MAJOR PROJECT ASSESSMENT

MP 09_0148

***Meriton Multi Unit Residential Development
12-40 Bonar Street & 5 Loftus Street, Arncliffe
Proposed by: Meriton Apartments Pty Ltd***

Director-General's Environmental Assessment Report
Section 75I of the Environmental Planning and Assessment
Act 1979

September 21 - Shadow Diagram - 12noon

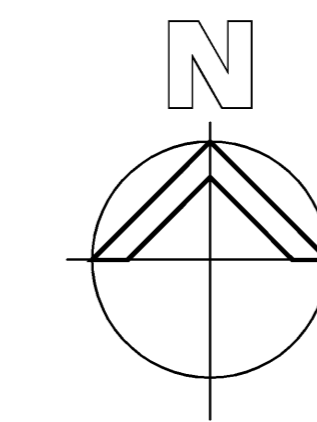
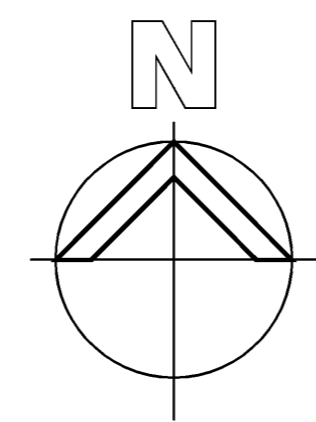
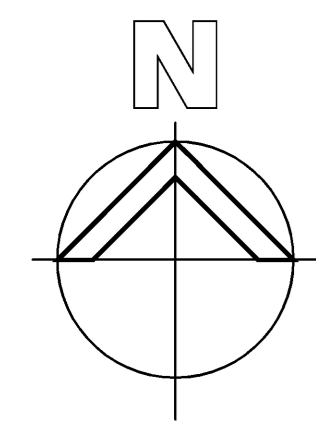
The Proponent submitted overshadowing diagrams to illustrate the impact of the additional height compared to a 21m complying building envelope. Proposed Building A will increase overshadowing to neighbouring properties to the west on the opposite side of Loftus Street in the morning, compared to a complying building envelope. Similarly, Building D will also increase overshadowing to the east on the opposite side of Bonar Street in the afternoon, compared to a complying building envelope. Despite the increase of overshadowing, the affected properties will still receive more than 3 hours of

The majority of overshadowing from a complying built form (4/6 storeys) is to the south, across Hirst Street, where lower scale residential dwellings are located. Shadow diagrams illustrate the majority of affected properties immediately adjoin the Hirst Street roadway. These existing properties receive more than 2hrs sunlight access, to a part of the property, in midwinter. Council's sunlight access control requires 3 hours throughout day during midwinter. On balance, the shadow impact is considered reasonable given that the affected properties lie adjacent to and on the interface with higher density development pre-determined by Council's controls for the Bonar Street Precinct. Further, the majority of the new shadows cast will be over the front yards of properties rather than private open space.

Further, the shadow diagrams also illustrate that the minor height variation of 1m sought from Council's standard controls for Buildings B and C do not increase the overshadowing impact on adjoining properties to the south, compared to a complying building envelope, as the additional height to Building B and C is setback from the Hirst Street edge. Given the impact that arises from a proposal with additional height is the same that arises from a fully complying proposal, the overshadowing impact to the properties on the opposite side of Hirst Street is considered to be reasonable in this instance.

SECTION A-A

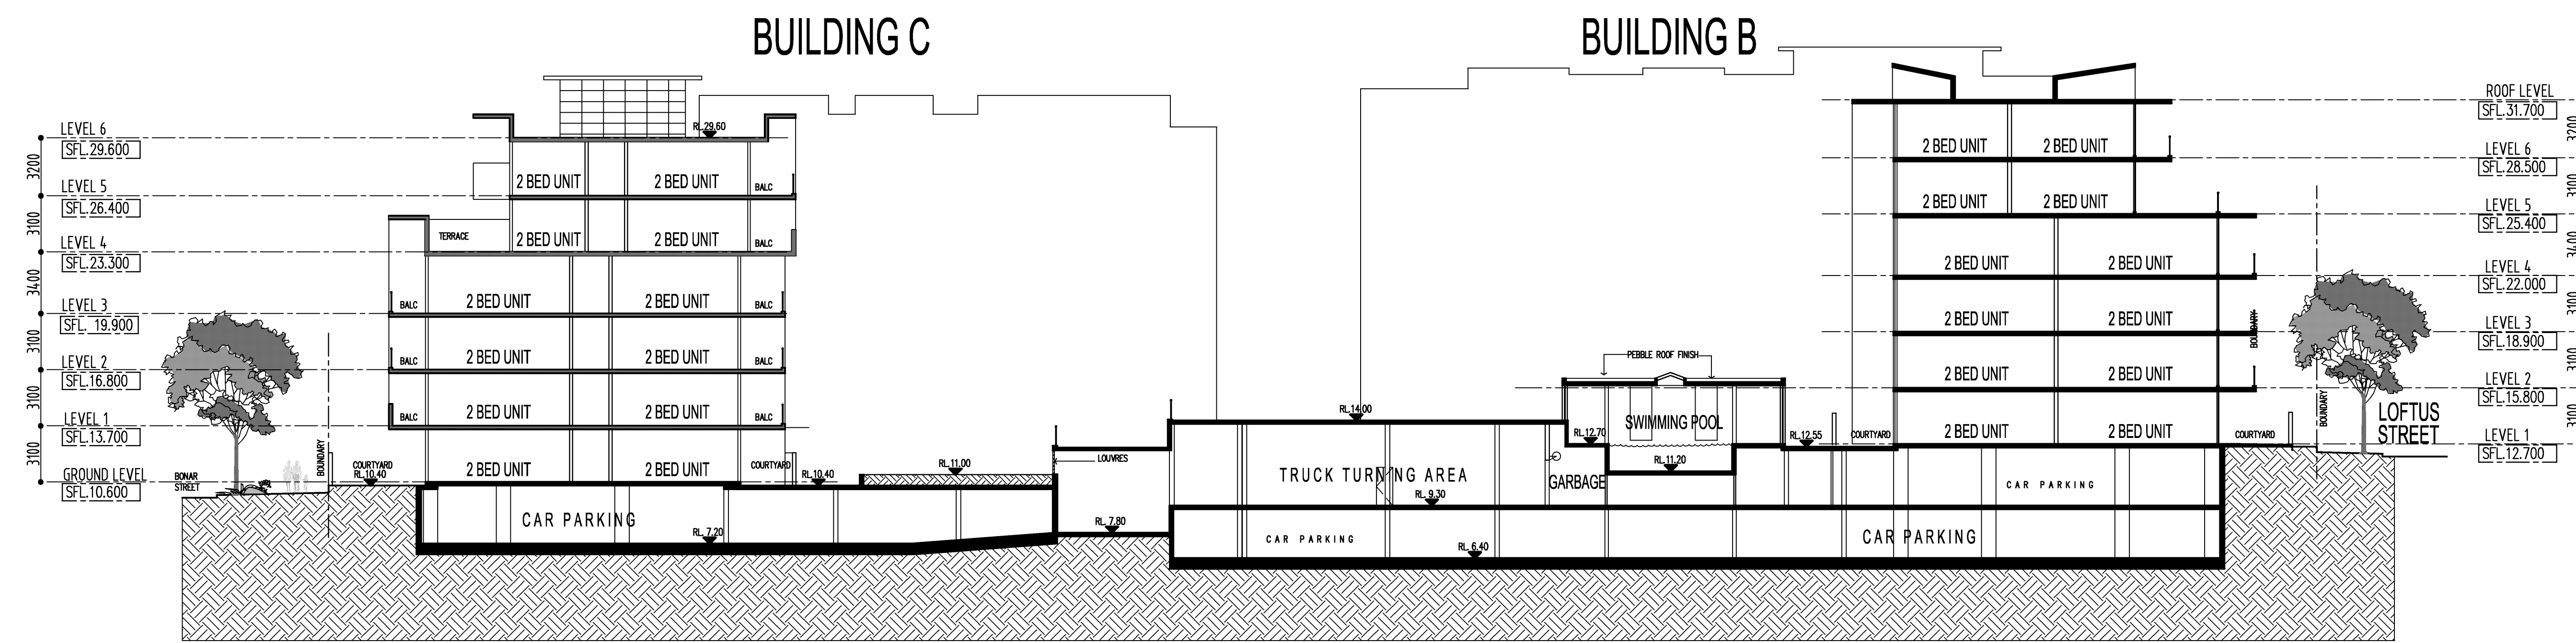
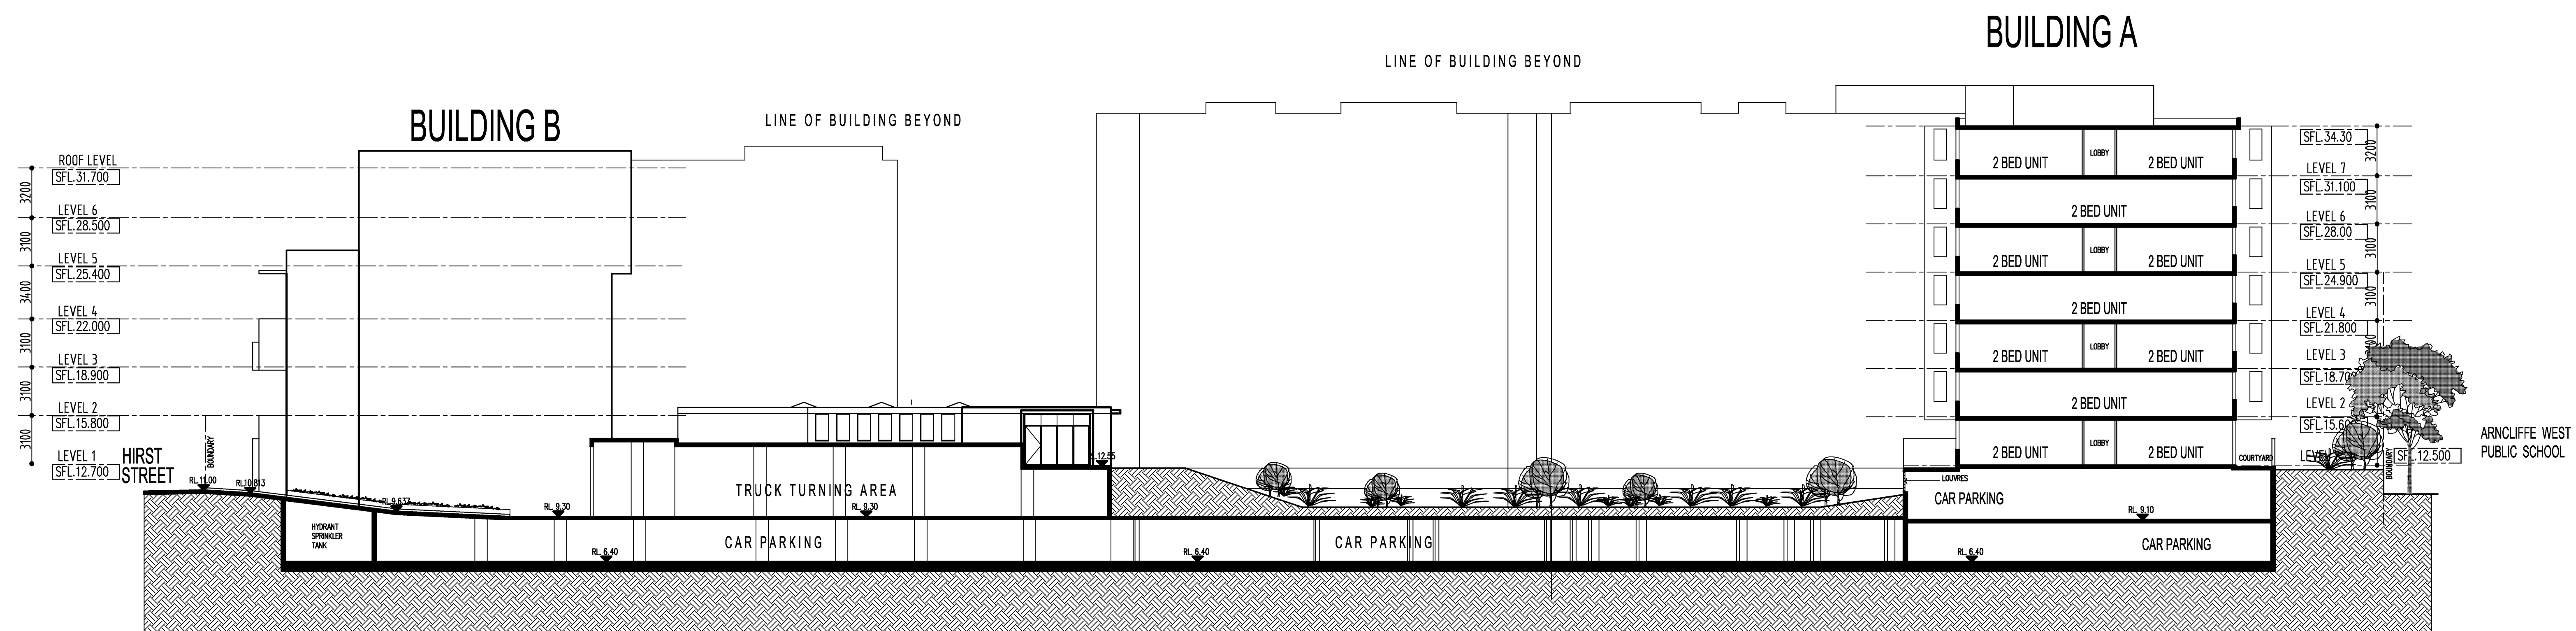
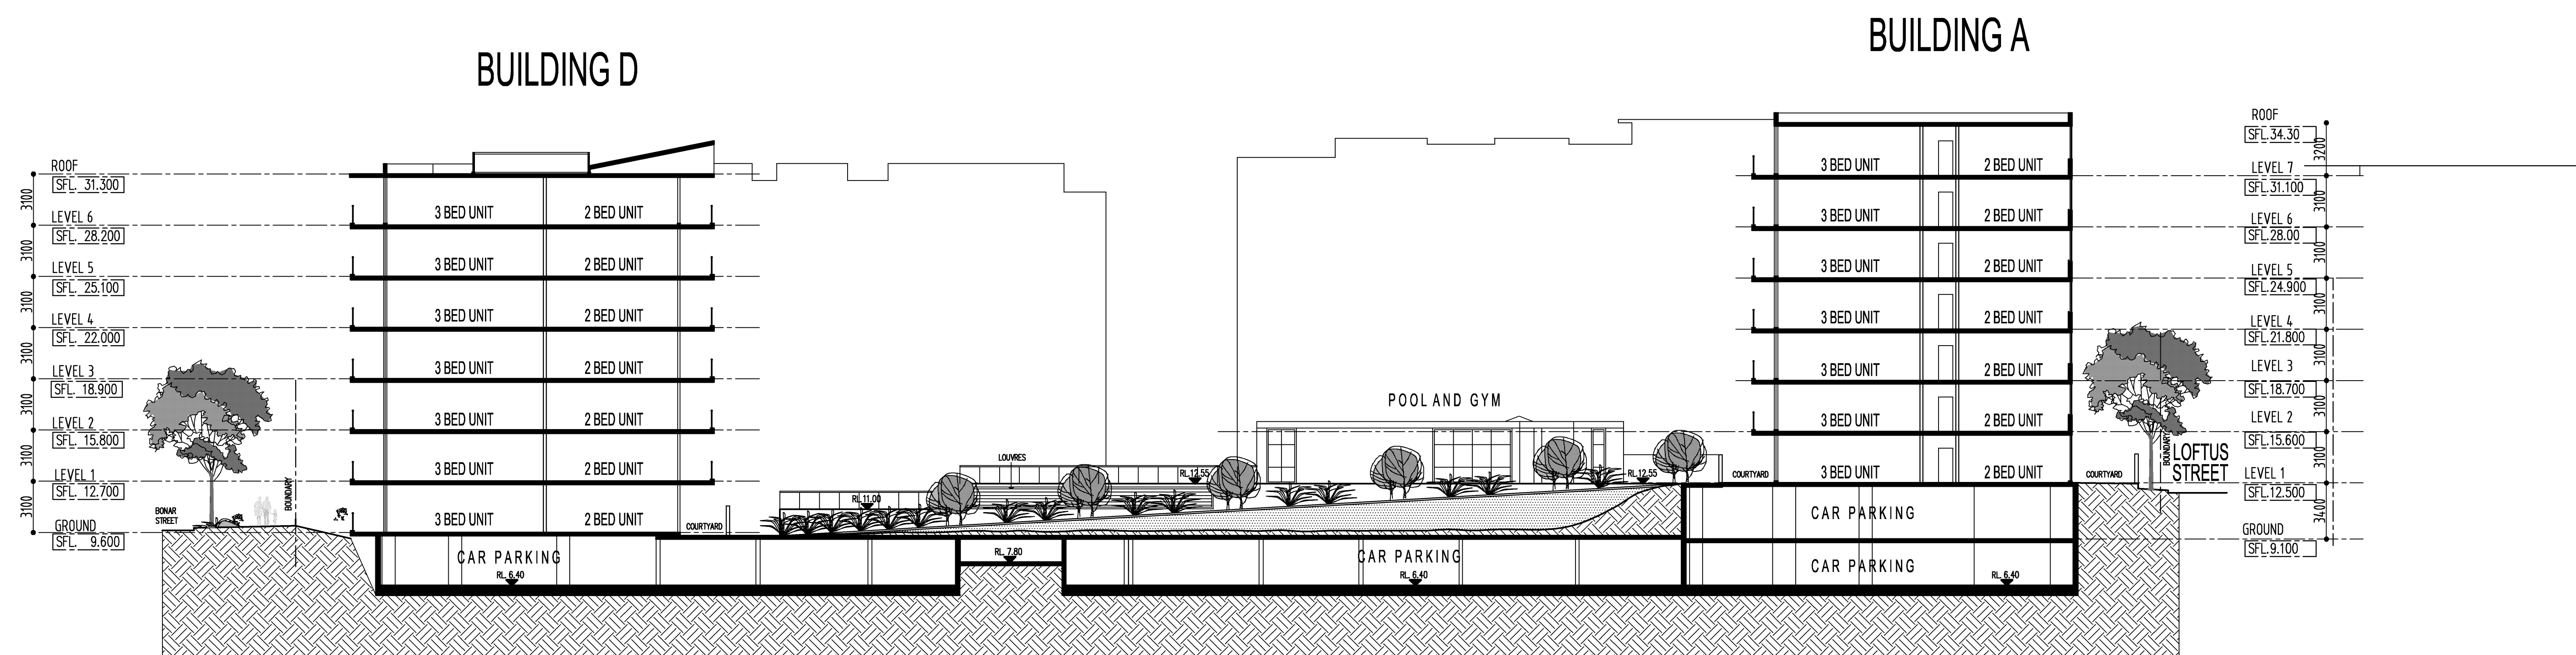
Rockdale Council and the Department both raised concerns with the height of the basement car park on frontages where it is elevated above ground level. The basement projection ranges between 1.2m and 1.6m above the ground level along Bonar Street and 1.8m and 3.4m along the northern property boundary shared with the school and Knoll Avenue residents. This has the potential to add unnecessary height to the building and a poor presentation to the street.

Where the basements are elevated above natural ground level and the proposal does not require clearance for flood protection, particularly for Buildings A and D, there is scope to reduce the

basement height. This will reduce the overall height of the building and will further minimise amenity impacts on surrounding properties, particularly overshadowing and privacy impacts. A condition is therefore recommended limiting basement projection to 1m above the proposed natural ground level along the property boundary shared with Knoll Avenue residents (Building D) and Arncliffe school (Building A). Subject to the above conditions, the Department considers the basement projections are acceptable.

In the PPR response, the proponent provided further justification noting that the basement car park is raised above street level along the Bonar Street frontage and a small part of the Hirst Street frontage to address the 1:100 year flood level. Further, additional landscaping is proposed along the Bonar Street frontage to better screen the elevated parking area.

The Department notes that the 1:100 year flood level ranges between RL10.2m and RL 12.4m and the proposed basement projection provides the necessary freeboard clearance ranging between 300mm-400mm above the flood level, in accordance with Council's controls. In this regard, the height of the basement projection is unavoidable in the circumstances. To mitigate the visual impact of the basements a condition is recommended requiring the landscaping of the street frontages to screen and soften the building facade.
